From: Laura Gibbons <Laura.Gibbons@arun.gov.uk>
Sent: 13 July 2021 15:20
To: Planning.Responses <Planning.Responses@arun.gov.uk>
Cc: Michael Eastham <Michael.Eastham@arun.gov.uk>
Subject: RE: Planning Consultation on: BN/86/21/DOC

Application No: BN/86/21/DOC
Registered: 23rd June 2021
Site Address: Land Rear of Lillies Yapton Road Barnham PO22 0AY
Grid Reference: 496408 104092
Description of Works: Approval of details reserved by condition imposed under ref BN/32/15/OUT relating to Condition No 6 - surface water drainage.

DETAILS SUDS CROSS SECTION

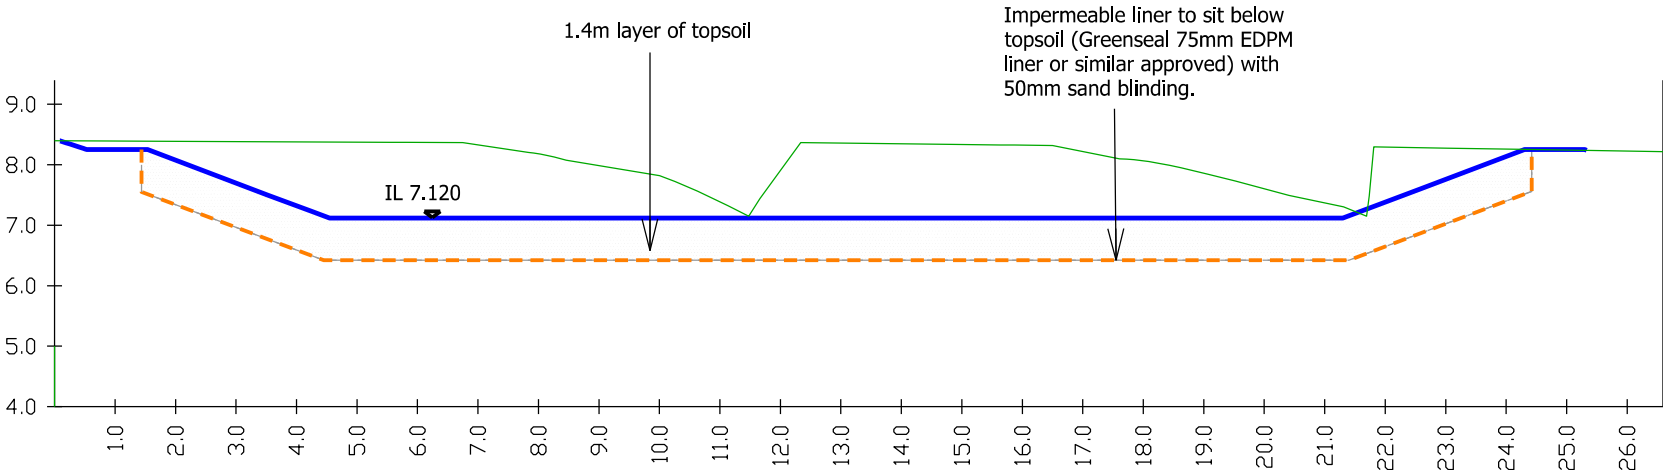
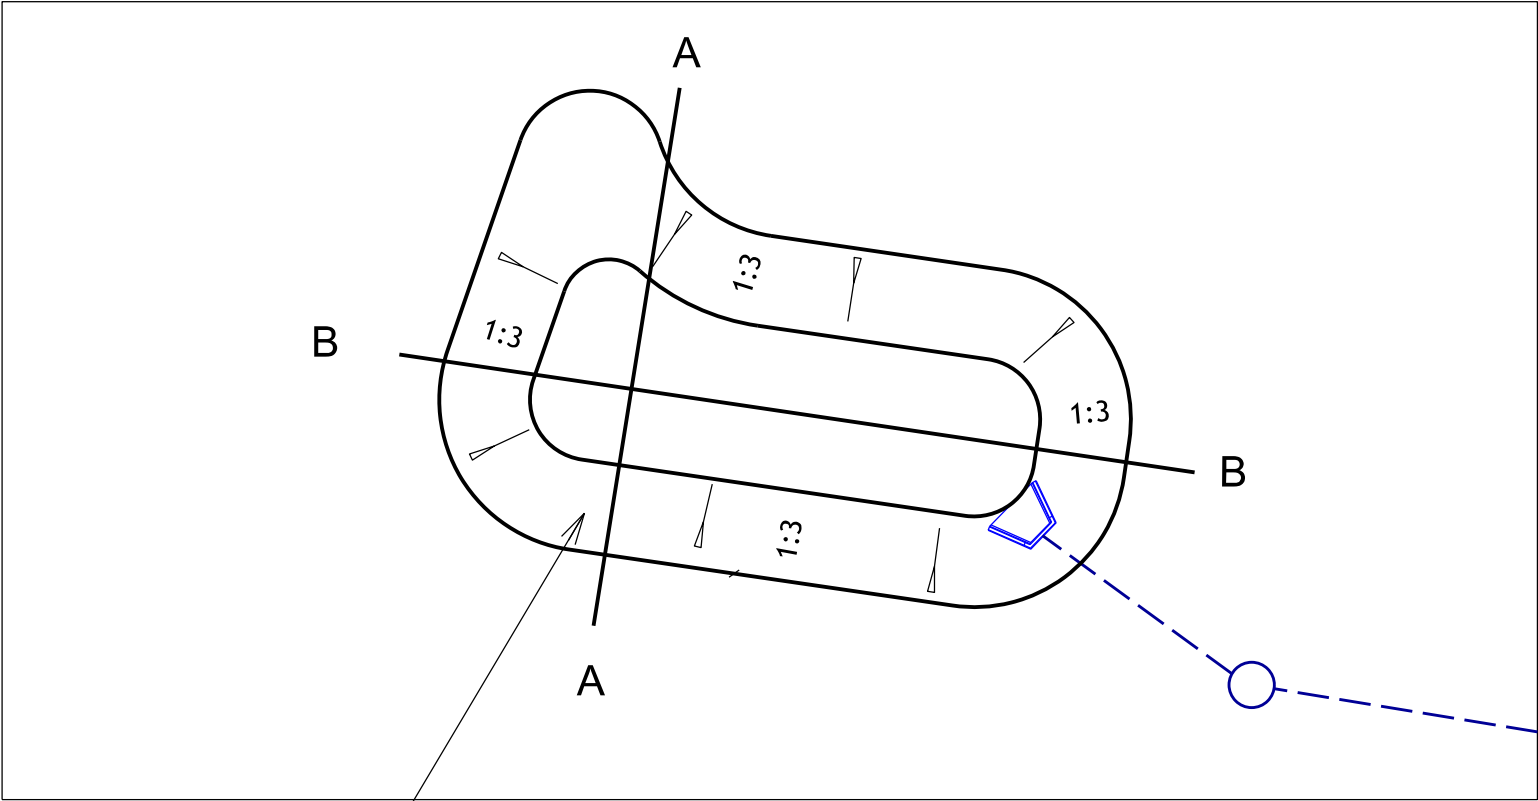
Condition 6 was previously discharged under BN/129/20/DOC. Although no covering note has been provided on the portal for this application it appears that the applicant is looking to alter the basin design only as part of this new application.

The groundwater monitoring data supplied as part of this application does not include any monitoring completed at the location of the proposed basin. It is also noted that half of the monitoring boreholes were deemed to have been impacted by onsite dewatering activities. Monitoring was not completed over the full winter with no data provided between mid-December and mid-February. As a result of these factors it is deemed that the groundwater monitoring results presented cannot be relied upon. The design approved under BN/129/20/DOC is still suitable.
